WSI responses to the “Response to Submissions” prepared for SSD70316465
11 July 2025

Figure 15: Yellow indicates built structures which penetrate the Figure 14 trigger surface i.e. Lots 2.7C and 2.8B

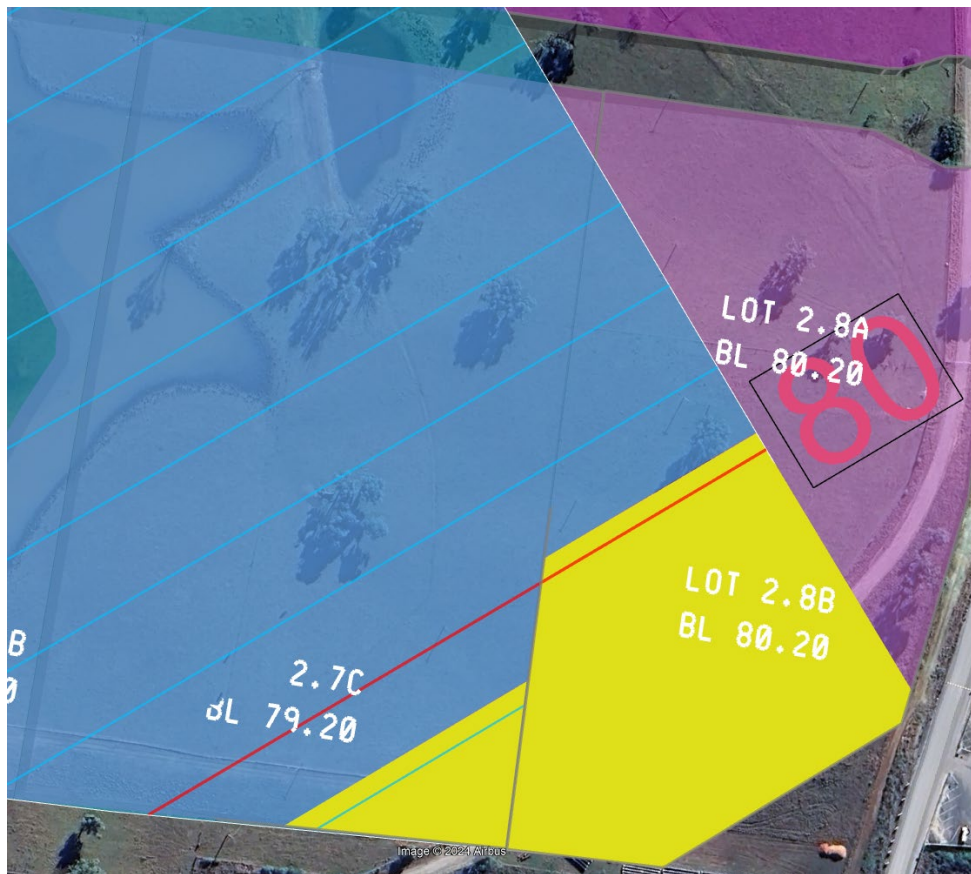
WSI Comment	Applicants Response	WSI Response (July 2025)
Concept Plan		
General Aviation Safeguarding The Building Envelopes and GFA for Superlot 2b, specifically lots 2.7c, 2.8 and 2.8b should not be approved in the current form as the compliance with the airport safeguarding provisions of the Western Parkland City SEPP cannot be adequately addressed at a concept plan level of detail. A future, detailed SSD application, should set out the building envelopes, uses and GFA and heights in the southeastern corner (Superlot 2b).	Agreed	It is noted that the applicant’s response agrees with WSI’s original submission to not approve Superlot 2b. This needs to be reflected in the Concept Plan. The Concept Plan still shows details around building envelopes, GFAs and heights etc. for Superlot 2b. An amended Concept Plan should be prepared that address the comments in relation to Superlot 2b (lots 2.7c, 2,8 and 2.8b) Comments still apply

Figure 20: NASF lighting zones overlaid the site and the lots

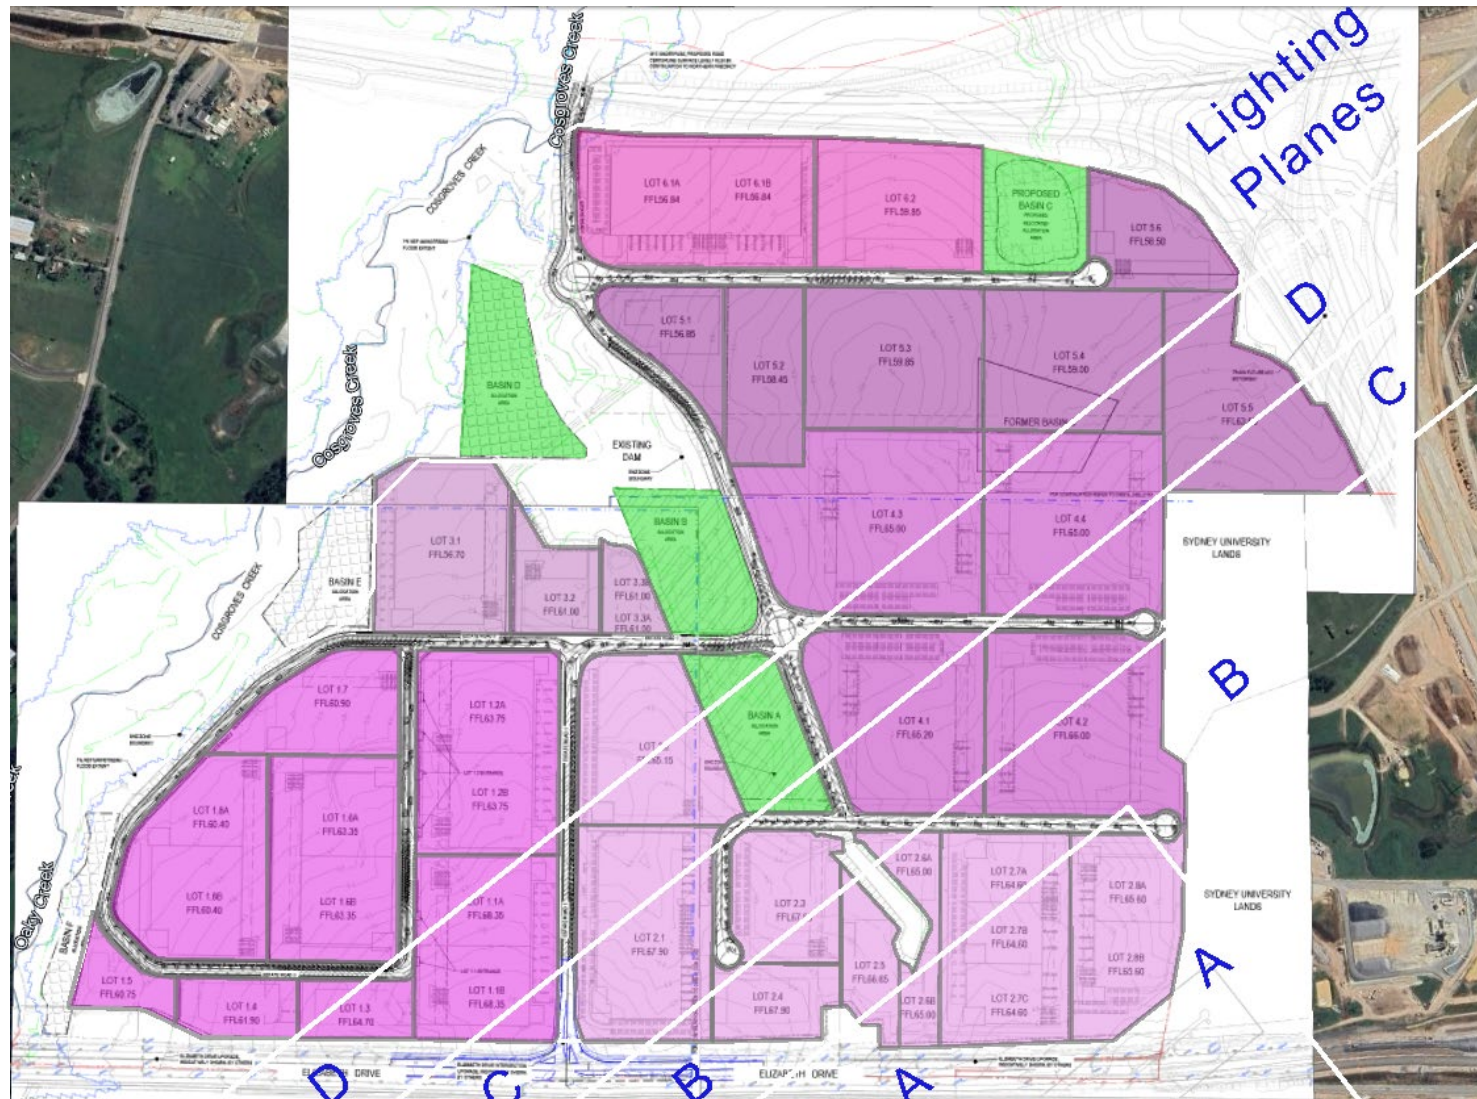
Future stages are to show building envelopes/heights in 3D against the 1:35 plane to enable assessment.		
Lighting Noting the general aviation safeguarding comment above, the future lots 2.7A, 2.7B, 2.7C, 2.8A, 2.8B are located within a Lighting Intensity Zone A. Lighting is to comply with Lighting Intensity Zone Future developments must comply with the requirements under the NASF Guideline D requiring, in particular that lighting must not exceed the intensity of light 0 candela (cd) above a 3-degree horizontal. WSI acknowledges that the application was referred to CASA by DPHI and that they provided comments in relation to lighting including: street/security lights are not to shine upwards and are not to have green, red or white arrays of lights.	Agreed and consistent with the assessment in Section 5.4 of Avlaw's report	Comments still apply and should be reflected in conditions of consent.
